From: Laura Gibbons <Laura.Gibbons@arun.gov.uk>
Sent: 07 April 2021 09:46
To: Simon Davis <Simon.Davis@arun.gov.uk>
Cc: Planning.Responses <Planning.Responses@arun.gov.uk>
Subject: RE: Y/155/20/DOC and Y/3/21/DOC - Condition 10 and 9

Key
16/02/21 ADC Comments

BILSHAM ROAD, YAPTON			
Drawing Title: PRELIMINARY ENGINEERING LAYOUT. SHEET 2 OF 2			
Client: BILSHAM ROAD DEVELOPMENT LLP			
Scale: 1:500 @A0	Date: FEB 20	Designed: NA	
Drawn: LS	Checked: JH	Approved: GG	
Job No: 19-326	Drawing No: 19-326/010	Rev: J

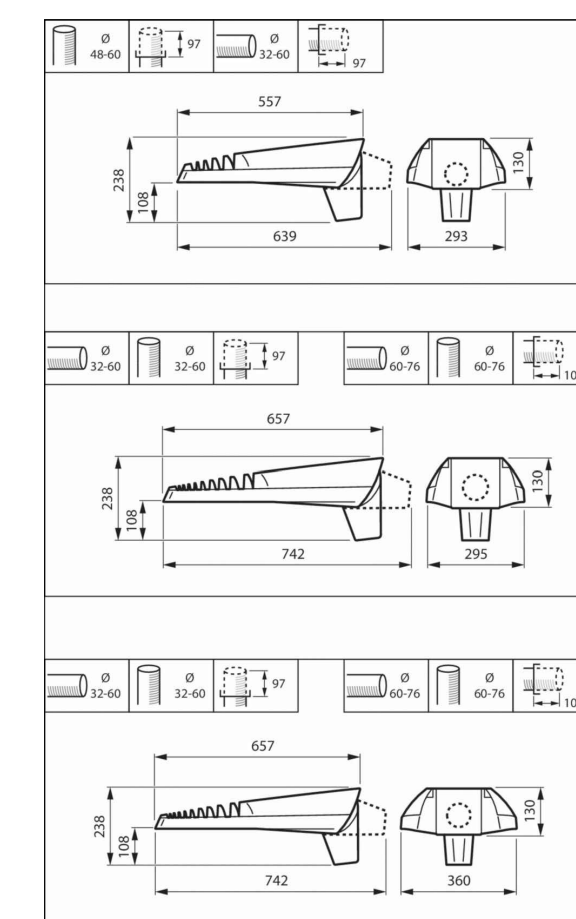
2. Groundwater monitoring results must be provided and should be overlaid on detailed drainage layout drawings. *The results of groundwater monitoring are provided in Drawings 19-326/009 and 19-326/010 in Appendix B. Okay, thank you.*

3. Detailed layout plans must be provided.
 - a. All pipes must be labelled with diameters and falls. *The diameters of the proposed pipes were included in the submitted drainage strategy drawings. The falls have been added to show the gradient of the pipes, and are shown in Appendix B. Okay, to be reviewed (see below for details of why this hasn't been reviewed yet).*

- b. Manhole invert and cover levels must be provided. *The invert and of cover levels of the proposed manholes are shown in Appendix B. Okay, to be reviewed (see below for details of why this hasn't been reviewed yet).*

P19-326 - Bilsham Road, Yapton RMT Technical Drawings 000 Series 19-326-010 Preliminary Engineering Layout Sheet 2 of 2.dwg

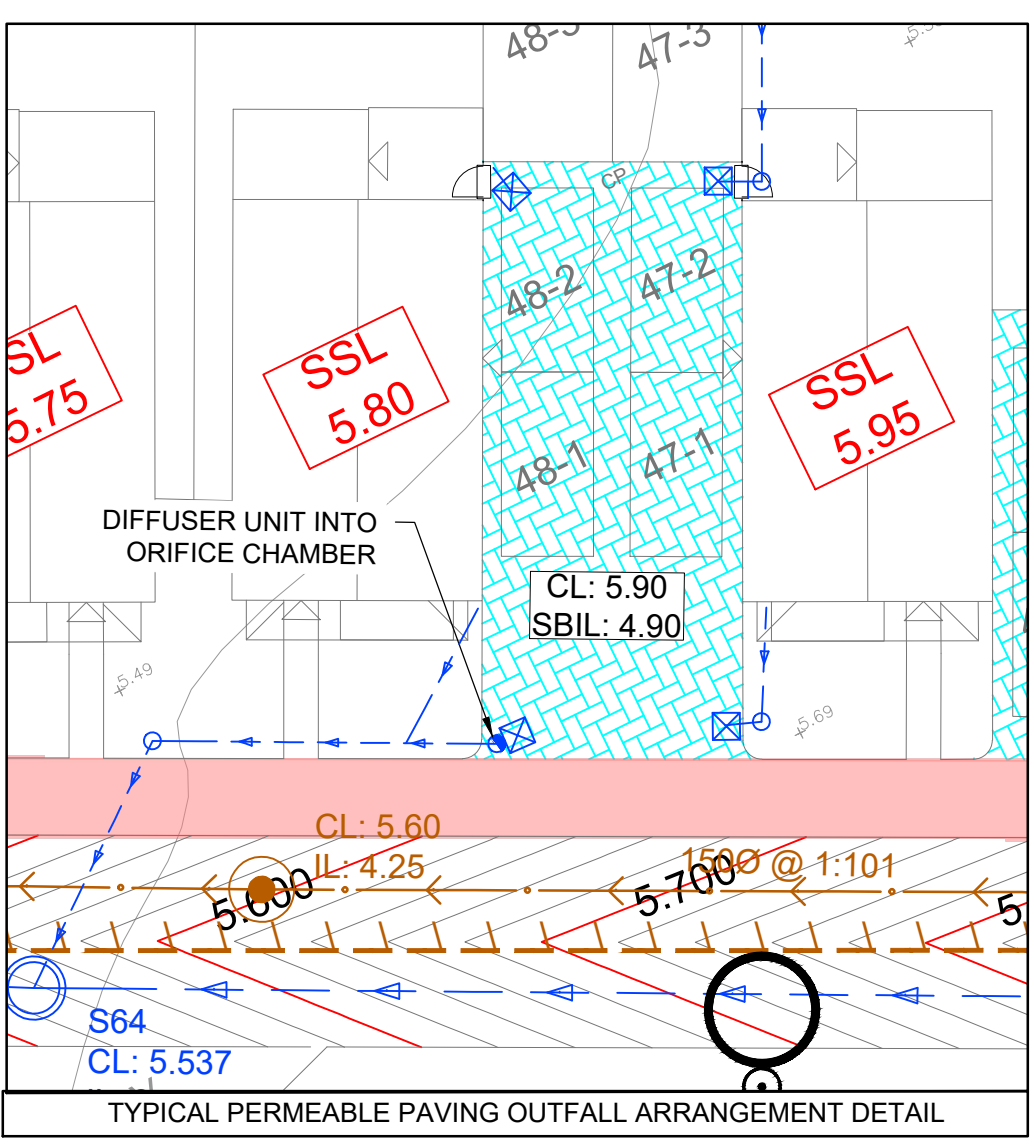
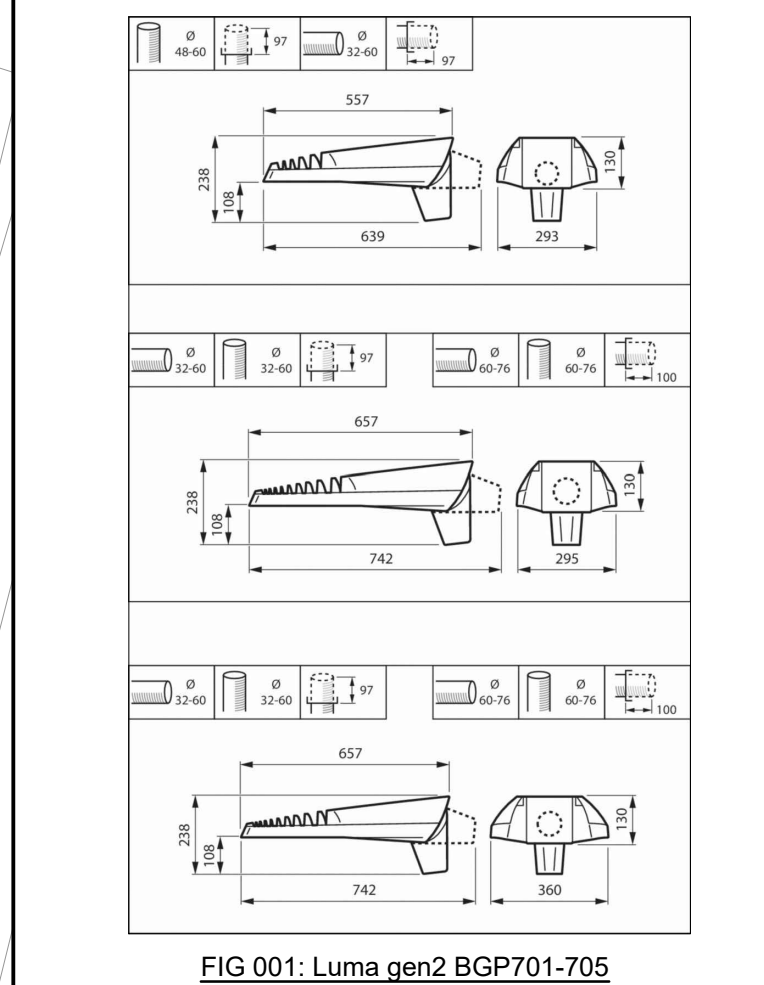
- c. Catchpits must be clearly identified. *Catchpits would be identified on drawings at detailed design stage. This information must be provided now in order to assess the adequacy of design and to ensure details can be listed on approvals and are enforceable.*

- d. Finish and formation levels of permeable paving must be detailed on plan. *The finish and formation levels of permeable paving would be provided on drawings at detailed design stage. This information must be provided now in order to assess the adequacy of design and to ensure details can be listed on approvals and are enforceable.*

- e. Layout plans must show connections from roads, driveways and plots to the drainage network. *Drainage connections for roads, driveways and plots would be identified at the detailed design stage. This information must be provided now in order to assess the adequacy of design and to ensure details can be listed on approvals and are enforceable.*

- f. Hydrobrake unit references must be detailed on plans and construction detail drawings. *Specific Hydrobrake unit references would be provided at the detailed design stage. This information must be provided now in order to assess the adequacy of design and to ensure details can be listed on approvals and are enforceable.*

- g. The invert level of the proposed connections to the culvert and watercourse must be provided, along with the invert level of these existing features at the proposed points of connection. Upstream and downstream bed levels of watercourses must also be provided on plans. *The invert levels of the proposed connections are provided within the drainage calculations in Appendix C. The invert level of the connection to the culvert has been interpolated using drainage survey data, and the invert level of the connection to the watercourse has been identified from the topographical survey included on the drawings in Appendix B. The invert levels must be provided on layout drawings. The*

achievability of the ditch outlet level of 4.41 is highly questionable with ditch bed levels in this area of at least 4.51, and a minimum of 150mm required between ditch bed and outlet invert level.

9. **A detailed review of calculations has not yet been undertaken due to the above. Please ensure that pipe reference numbers are included on layouts to facilitate review.** *The reference numbers of the proposed pipes have been added to the drainage strategy drawings and are shown in Appendix B. Okay, to be reviewed once further points are resolved.*

17. Note to be added to drawing to state that watercourses will be cleared of vegetation and silt as part of works. These works must be completed near the beginning of construction to ensure the free flow of water. *A note detailing the works to the watercourses has been added to the drawings in Appendix B. Okay.*

Flotation Calculations

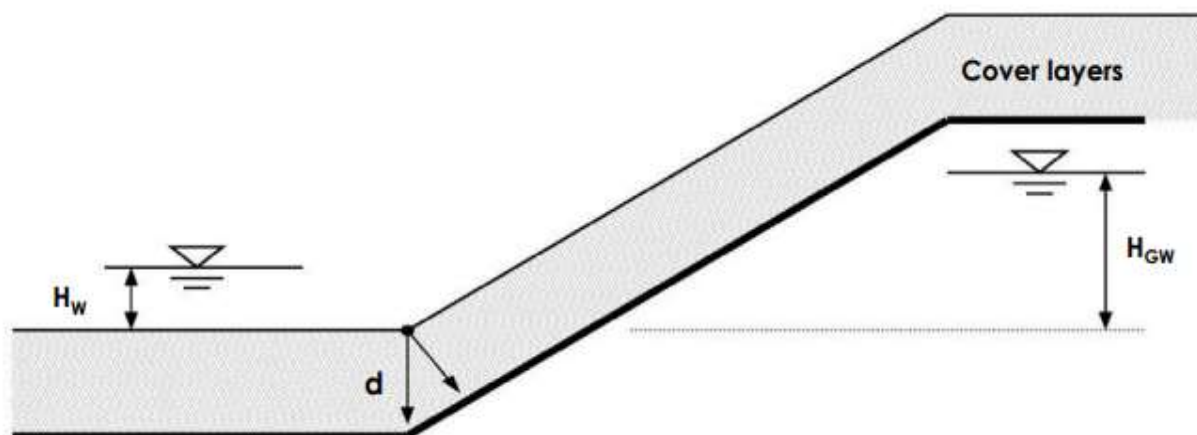
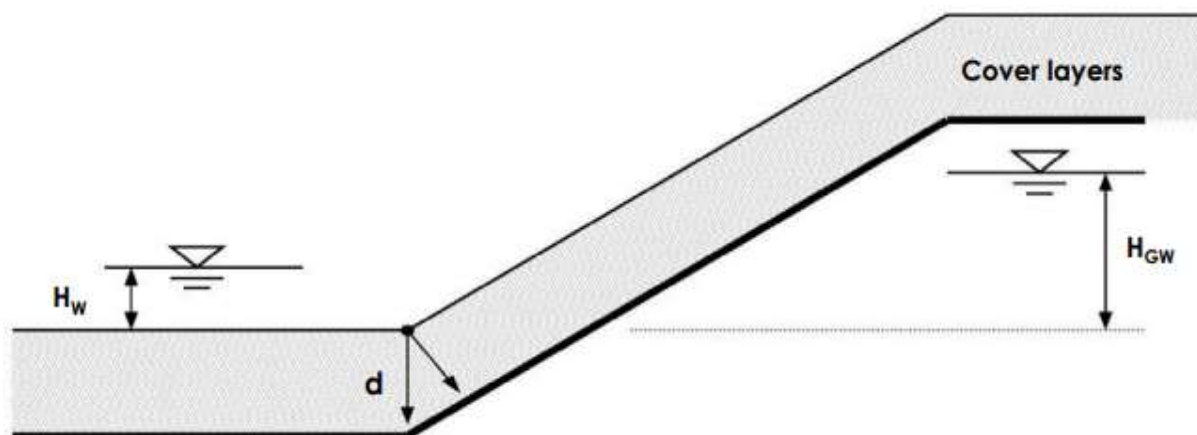
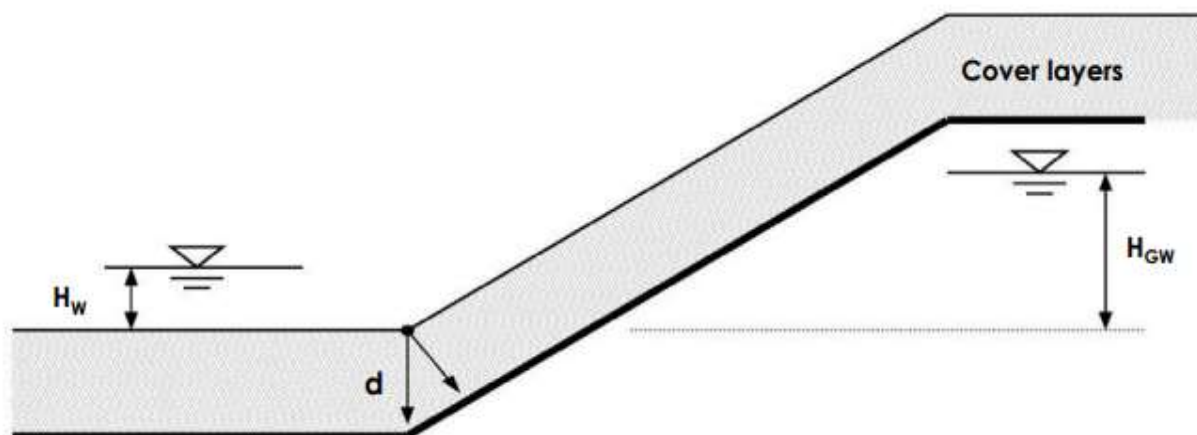
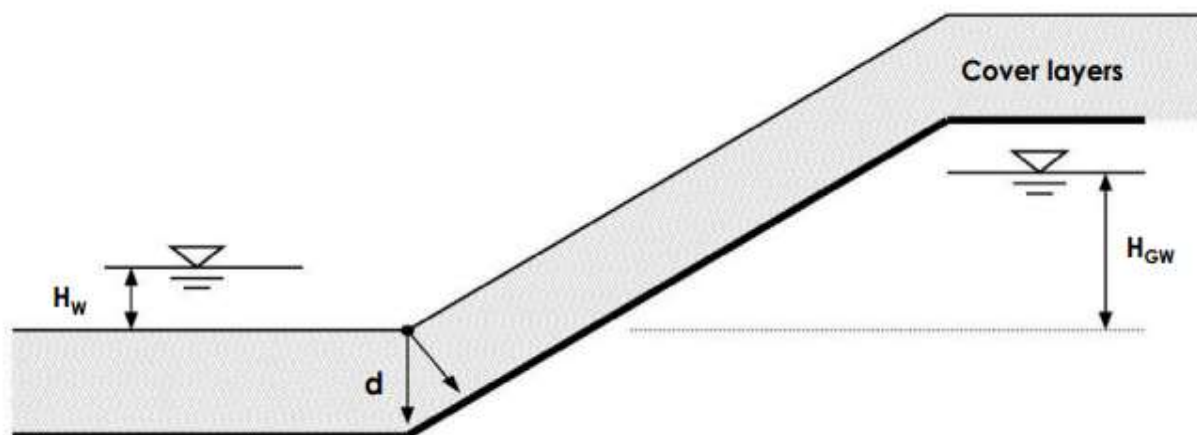
12. **Please clearly identify which features are to be lined and which are not. Please supply flotation calculations for lined features.** *The basins would require lining to protect against buoyancy. The flotation calculations are*

provided in Appendix E. A hybrid approach would be adopted with the permeable paving, whereby surface water runoff would be attenuated and discharged at the approved QBar rate to the watercourse network, whilst allowing infiltration in areas where permeable paving is located above groundwater levels. Calculations look okay, to be reviewed again once further information on basins has been provided. I.e. depths of all basins labelled on plans and cross sections provided.
